From: Louise Crane
Sent: 08 September 2017 14:58
To: Planning.Responses
Subject: FW: Planning Consultation on: LU/243/17/PL

Comments from Environmental Health and Private Sector Housing:

APPLICATION LU/243/17/PL

Description of Works:	Conversion & minor extension of existing restaurant & five bedroom flat to create a shop unit & 6 No. residential units (resubmission following LU/71/17/PL).
------------------------------	---

Drawing Title
Proposed Drawing
Lower and Upper Ground Floor Plans
1/100 @ A3

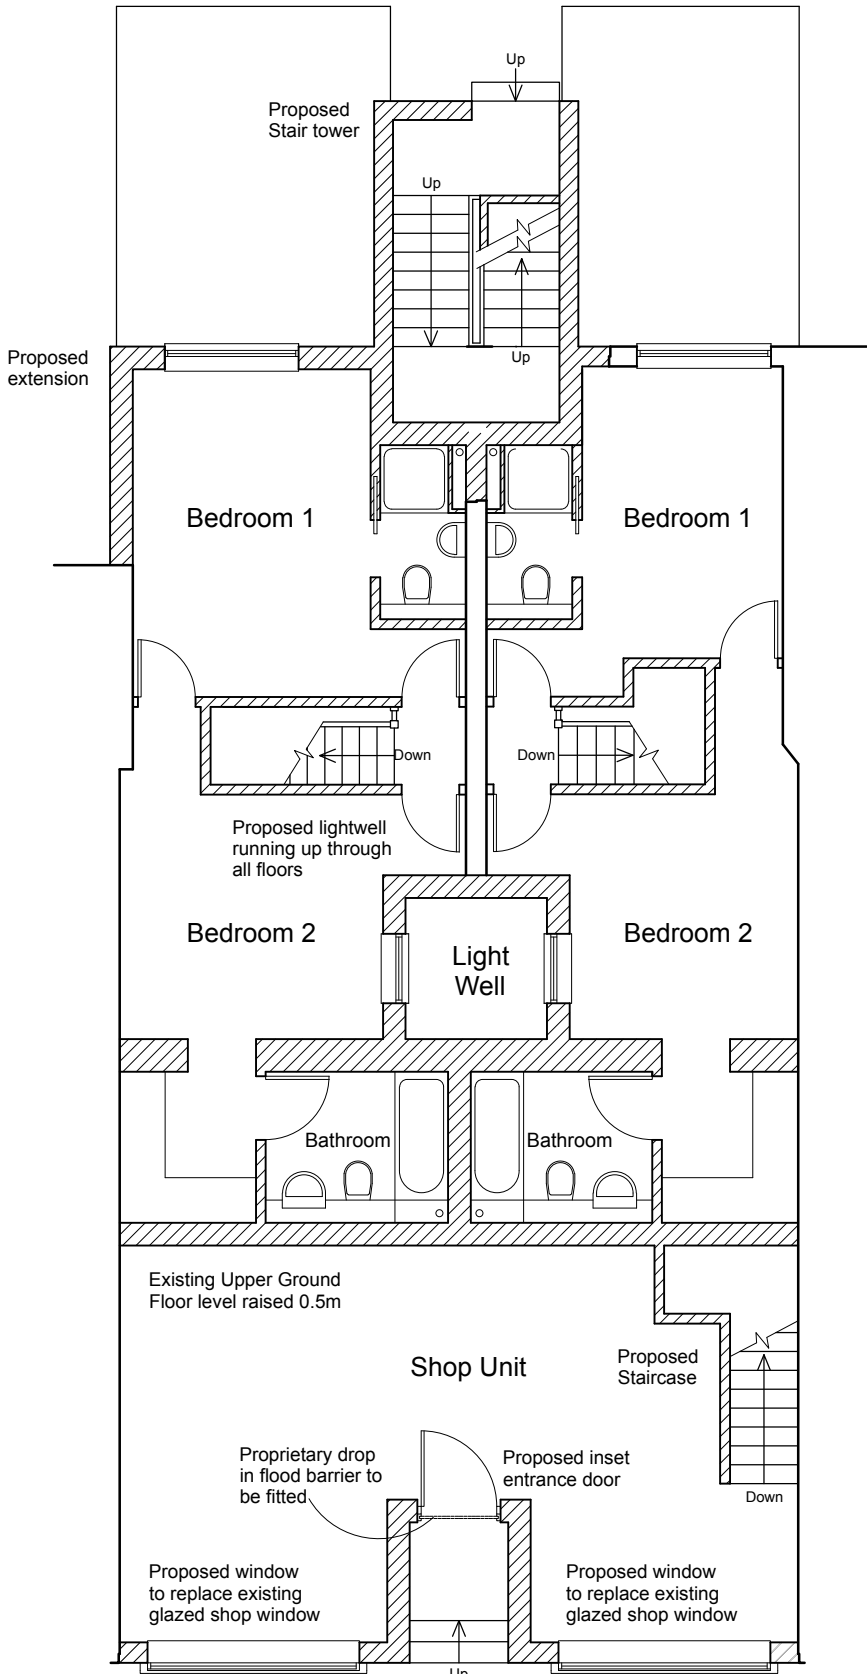
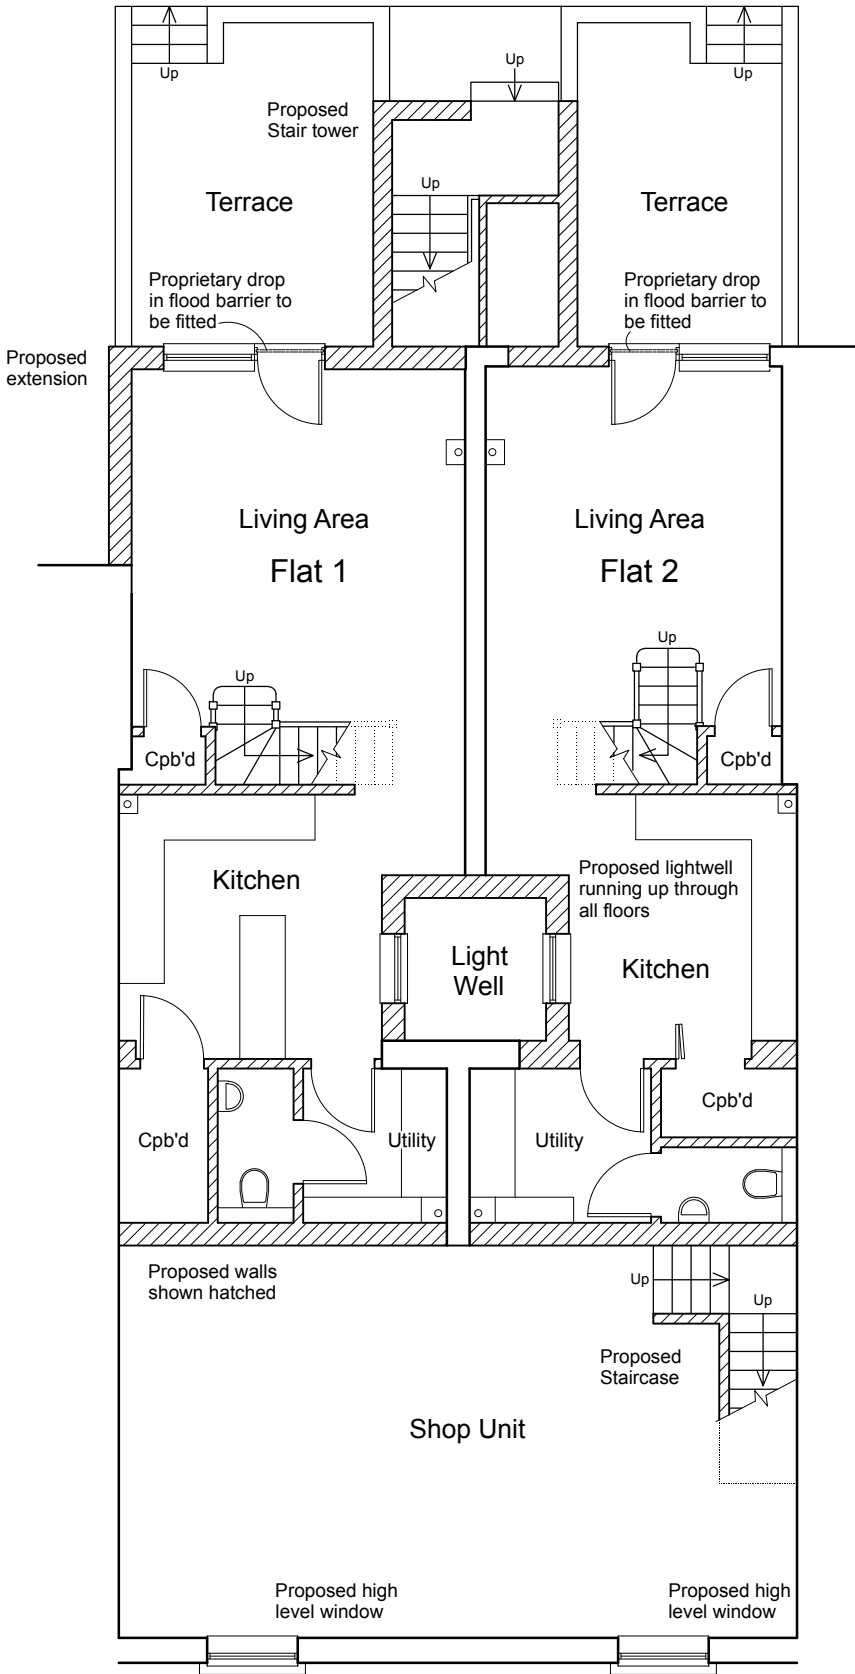
- A room where the only escape route is through another room is termed an “inner room” and poses a risk to its occupiers if a fire starts unnoticed in the outer room. The escape routes to all the flats is via the kitchen, this can be overcome in bedroom 1 of the upper ground floor and first floor by ensuring that the window in the bedroom is an escape window and adequate fire protection within the flat. However, due to the nature of the building being terraced this is not going to be possible in bedroom 2 of both flats on the upper ground floor and an escape window is not acceptable at second floor level therefore these flats must be redesigned to ensure adequate fire precautions.
